Recommendation Report for Planning Permission

REF NO: LU/106/15/PL

LOCATION: Willowbank Cottages
The Poplars
Littlehampton

PROPOSAL: Variation of condition 3 imposed under planning reference LU/203/13/ to enable the reorientation of plots 5 & 6.

1-6 Willowbank Cottages
The Poplars (Former HRI Site
Worthing Road , Littlehampton
West Sussex, BN17 6AZ
PLOTS 5 & 6
ELEVATIONS

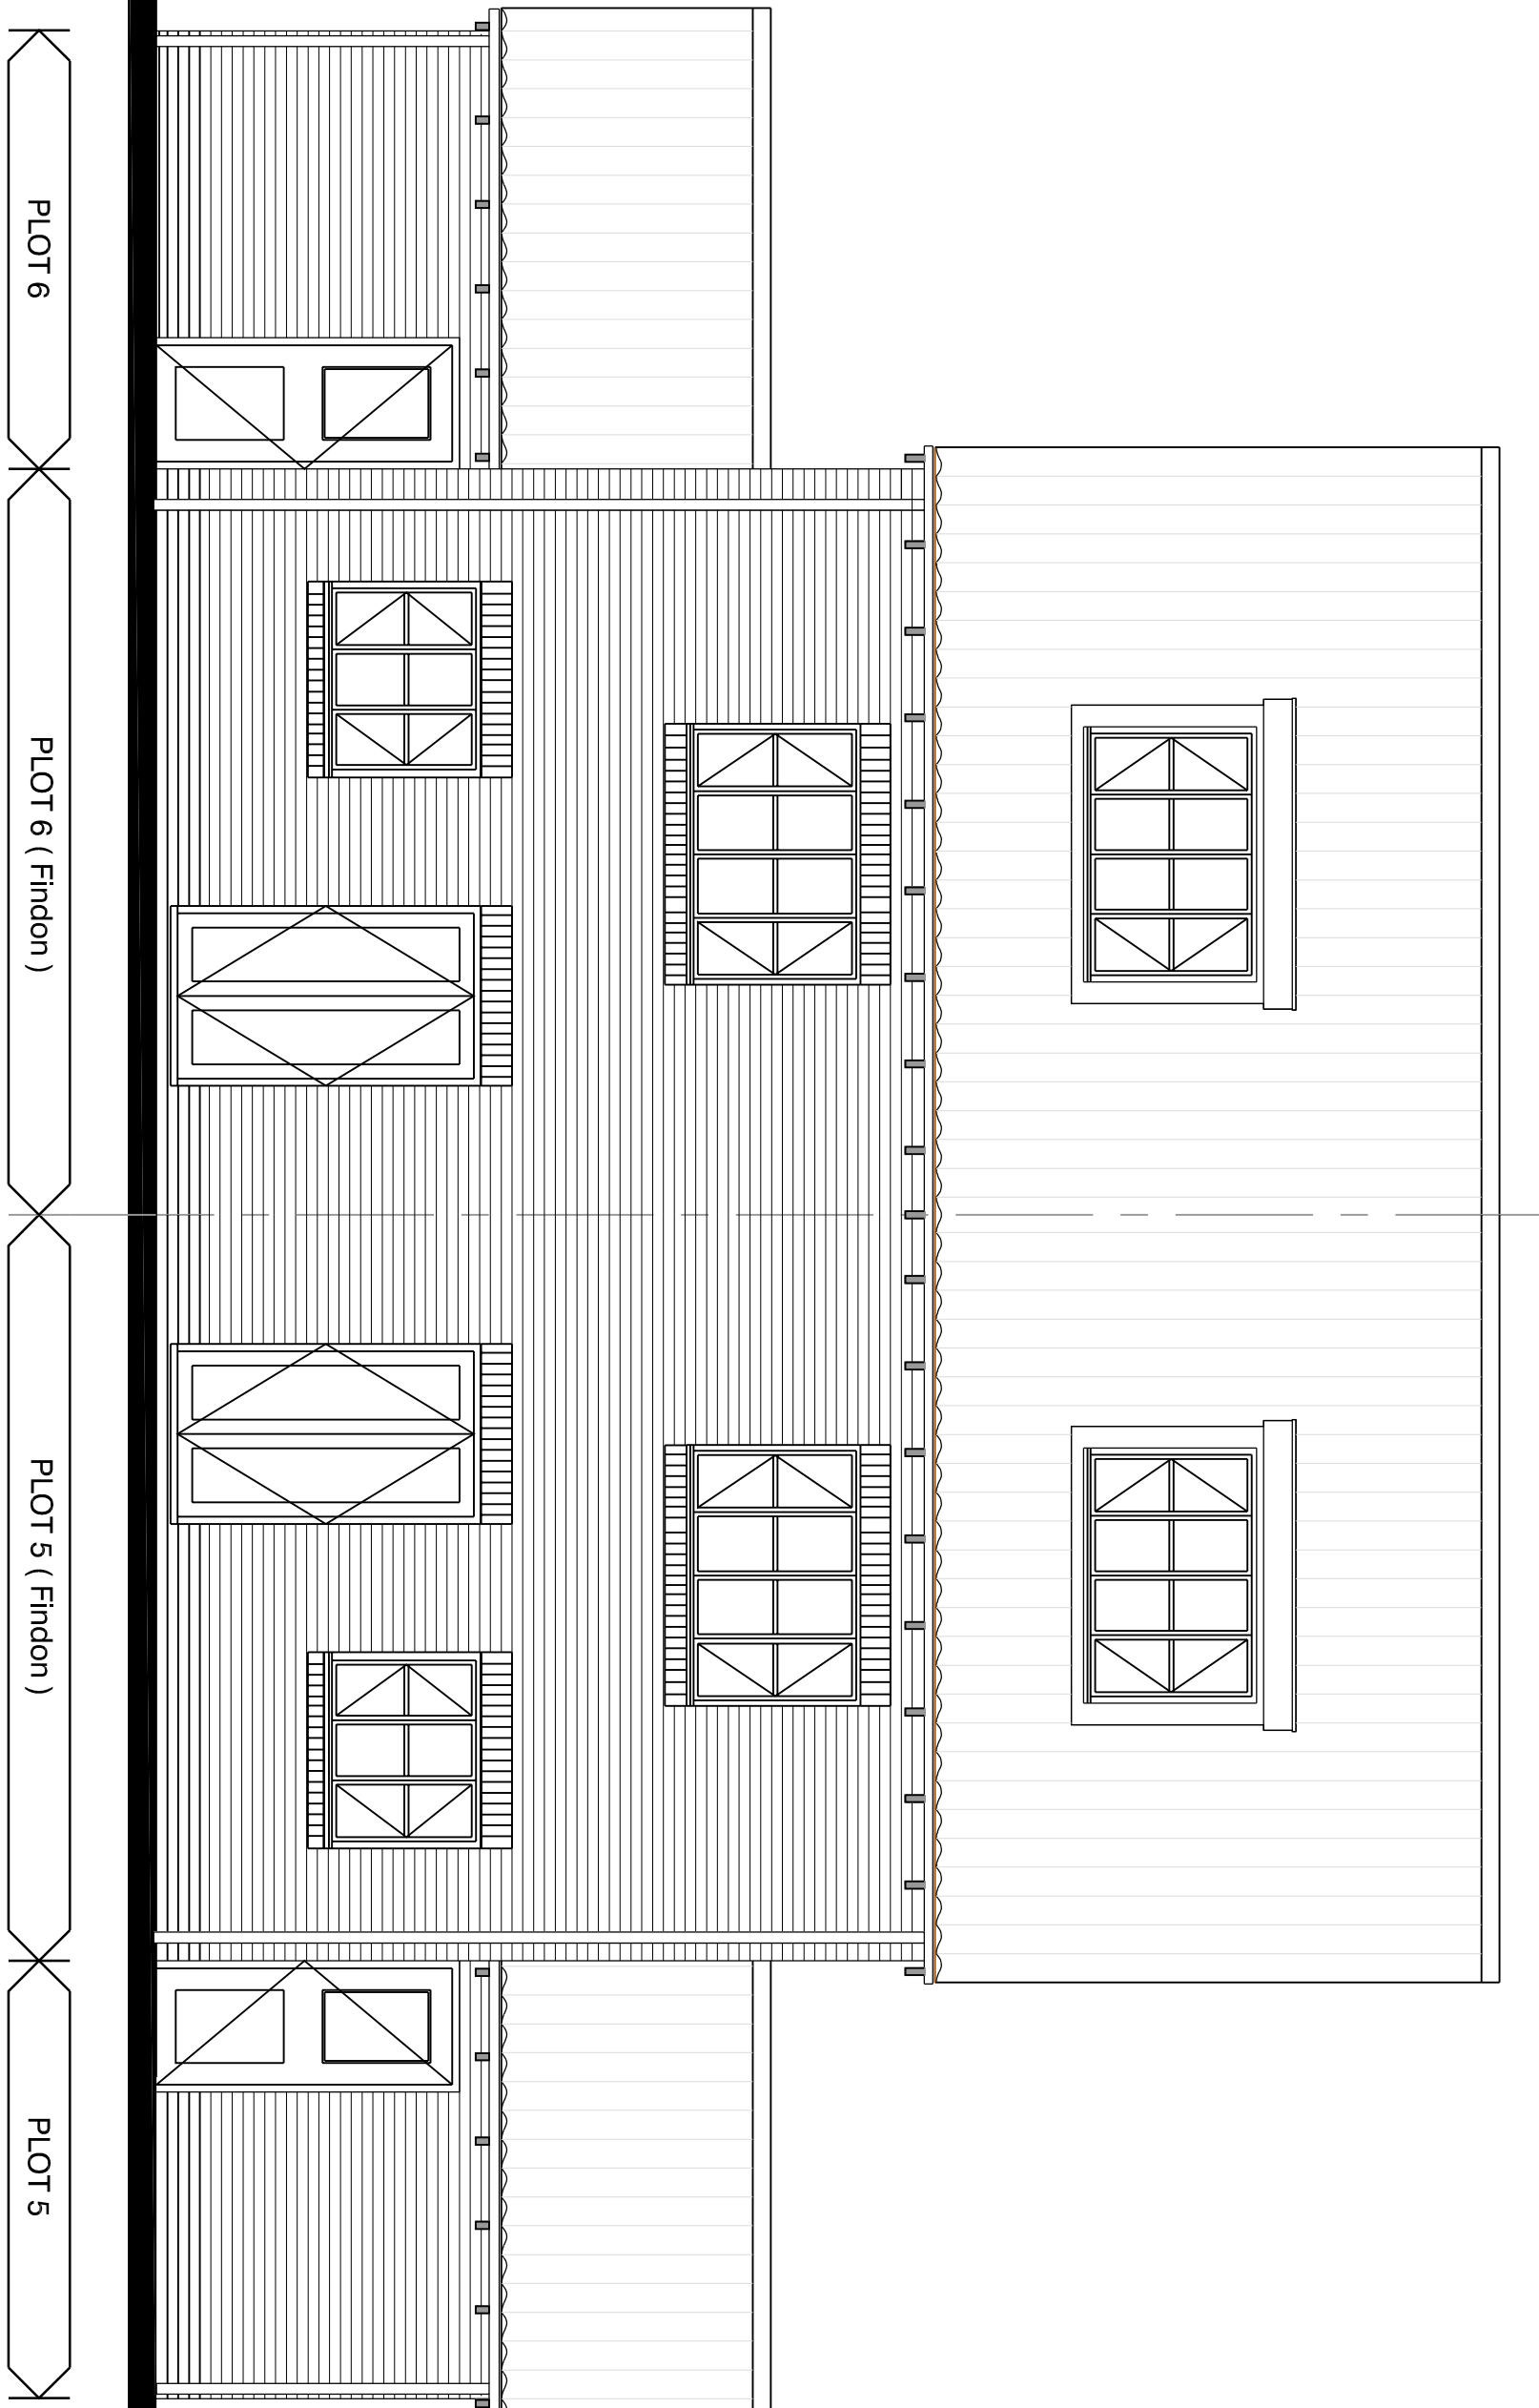
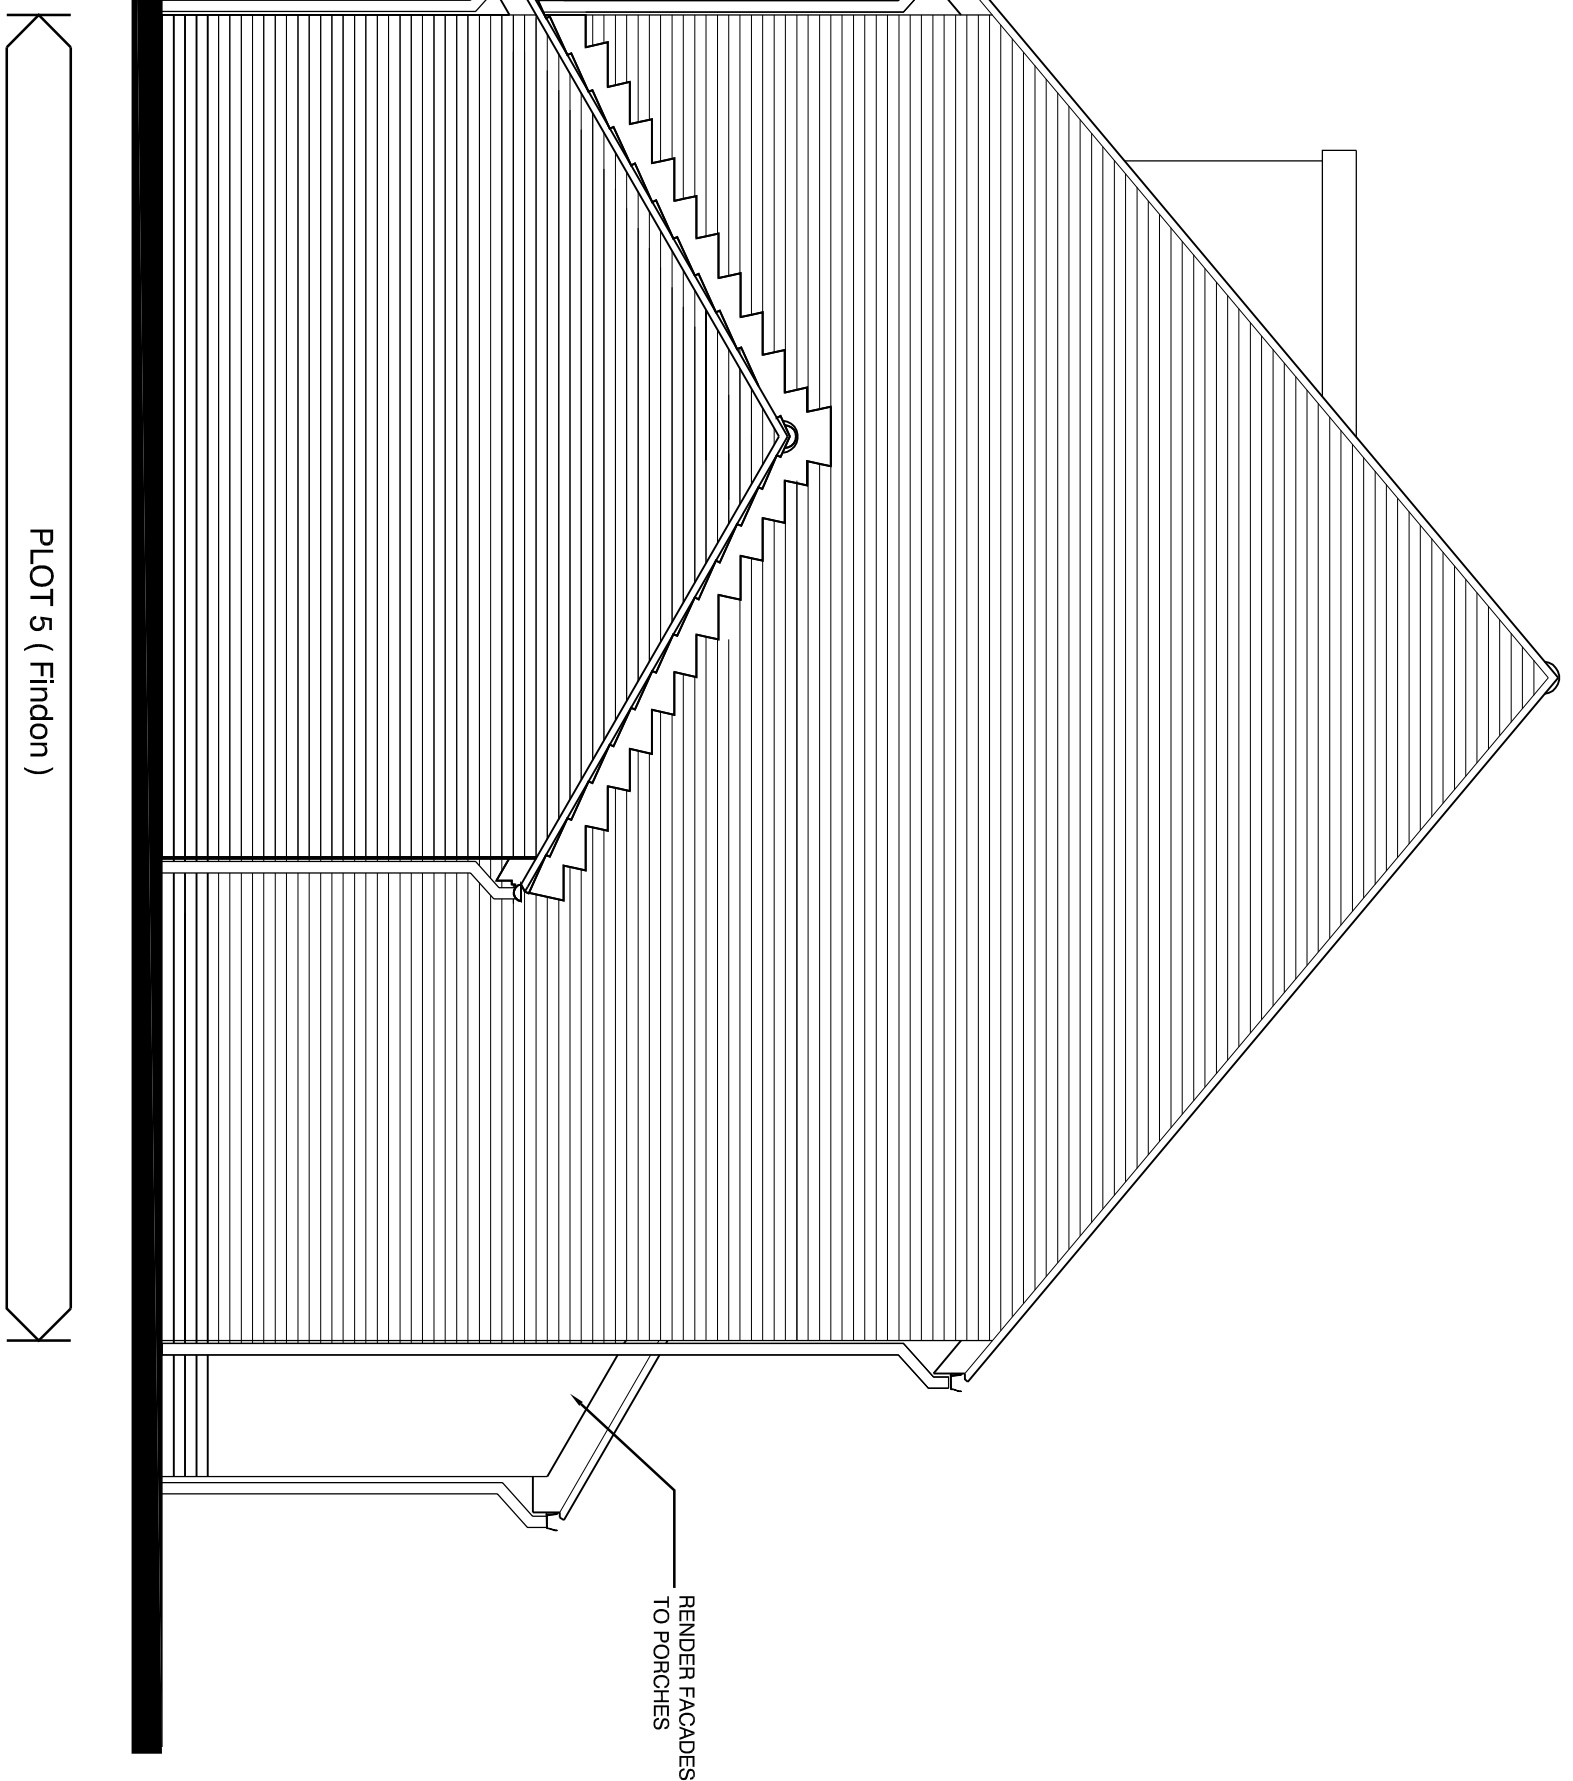
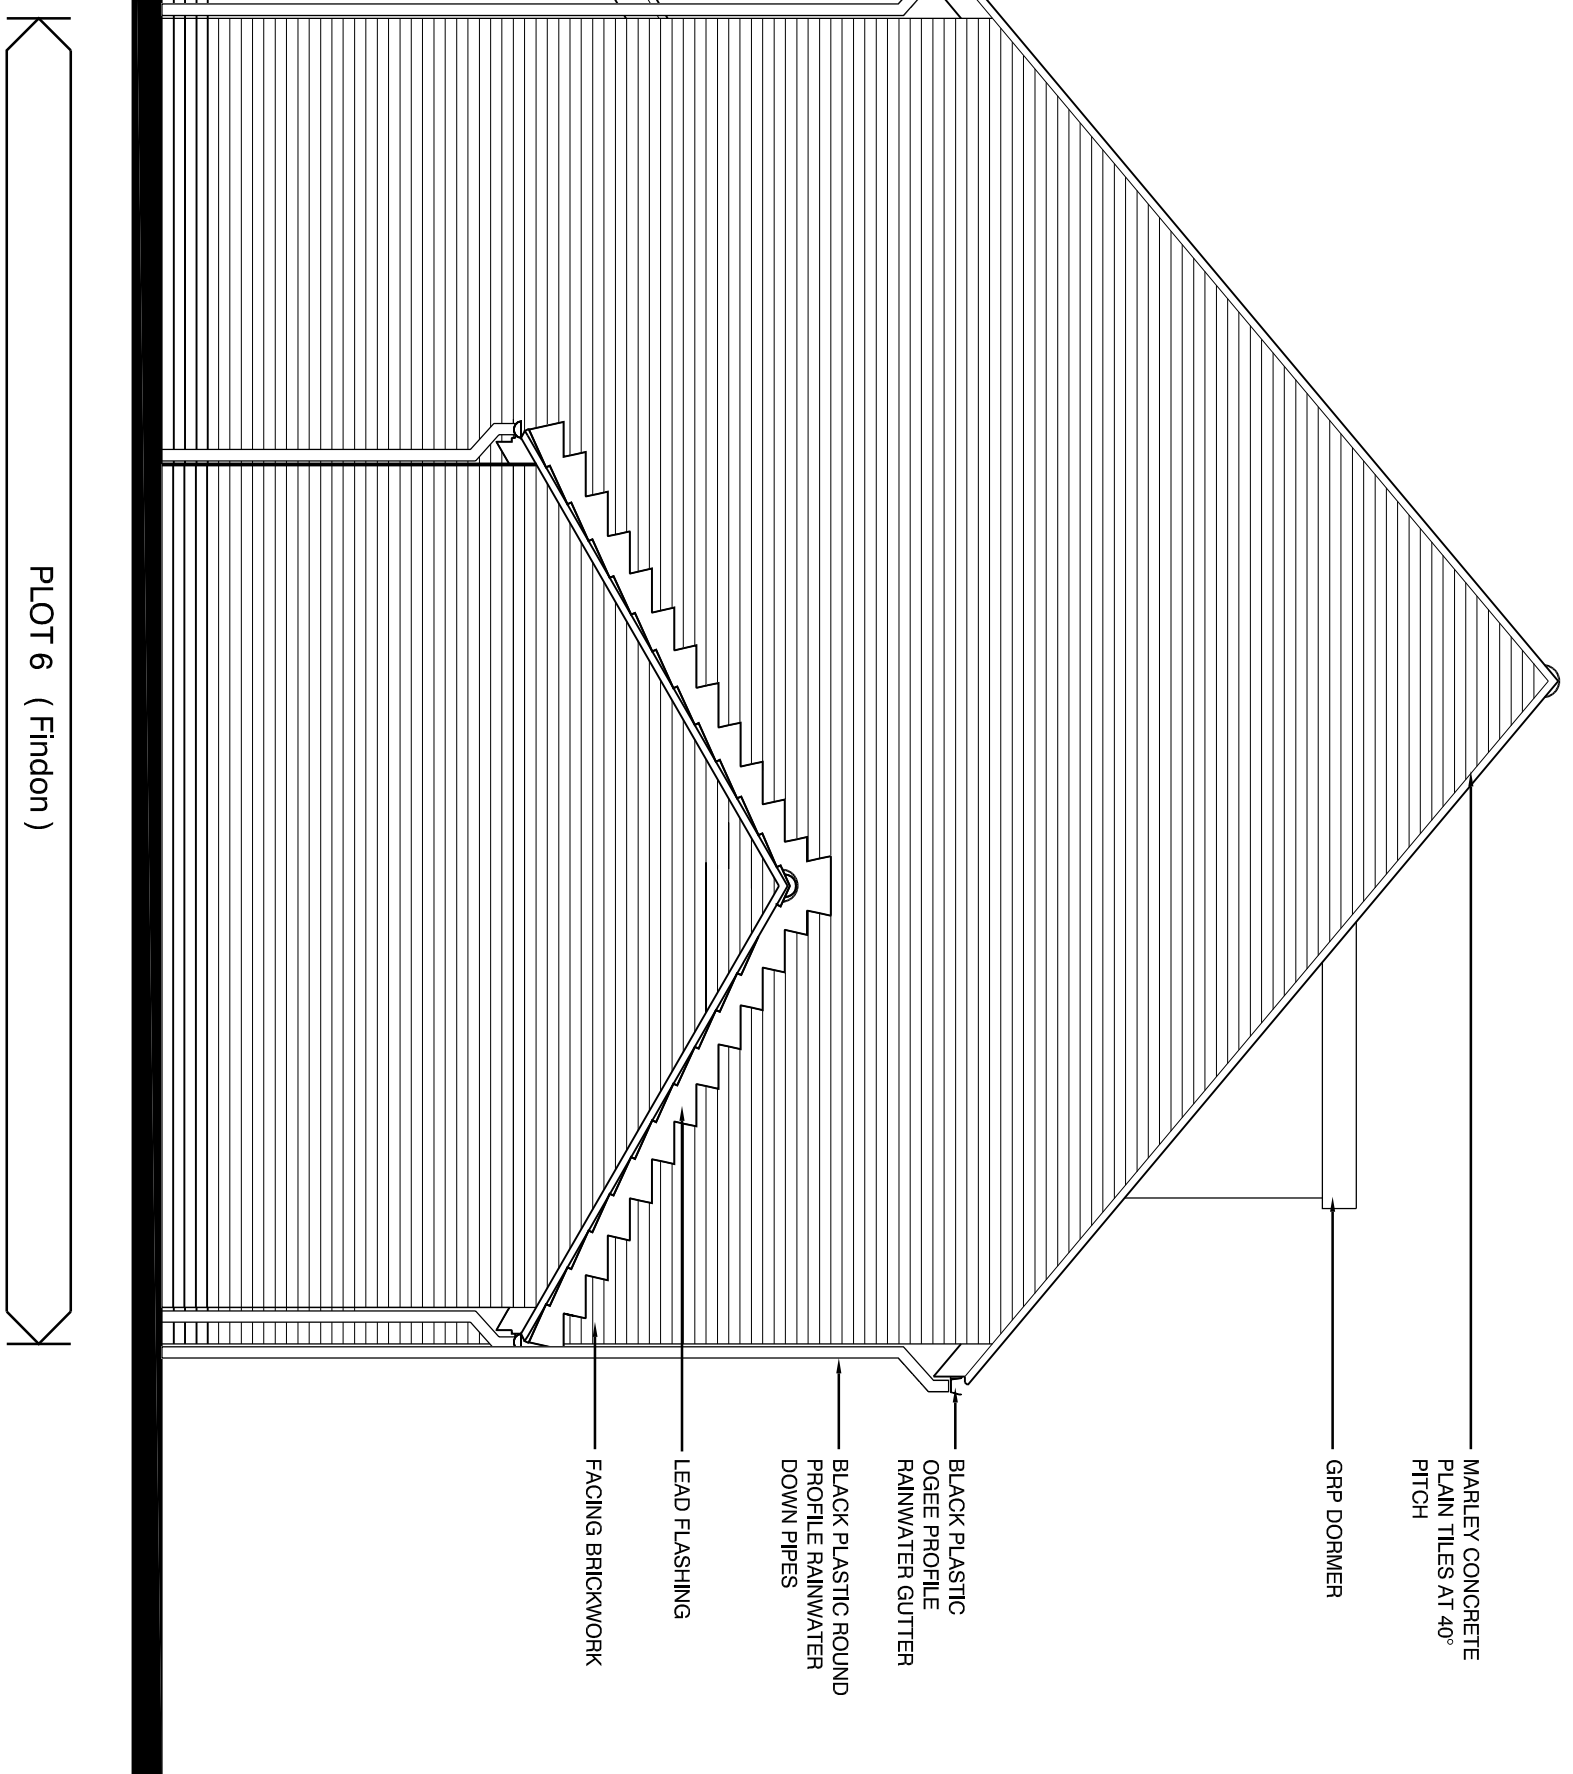
The proposed alteration to the previously approved layout also involves minor layout changes, namely repositioning the garages for Plots 5 and 6 (so as to be on either side of the semi-detached pair rather than both on the same side), and a revision to the garage for Plot 4 (setting it some 1.2m back along the side of that dwelling).
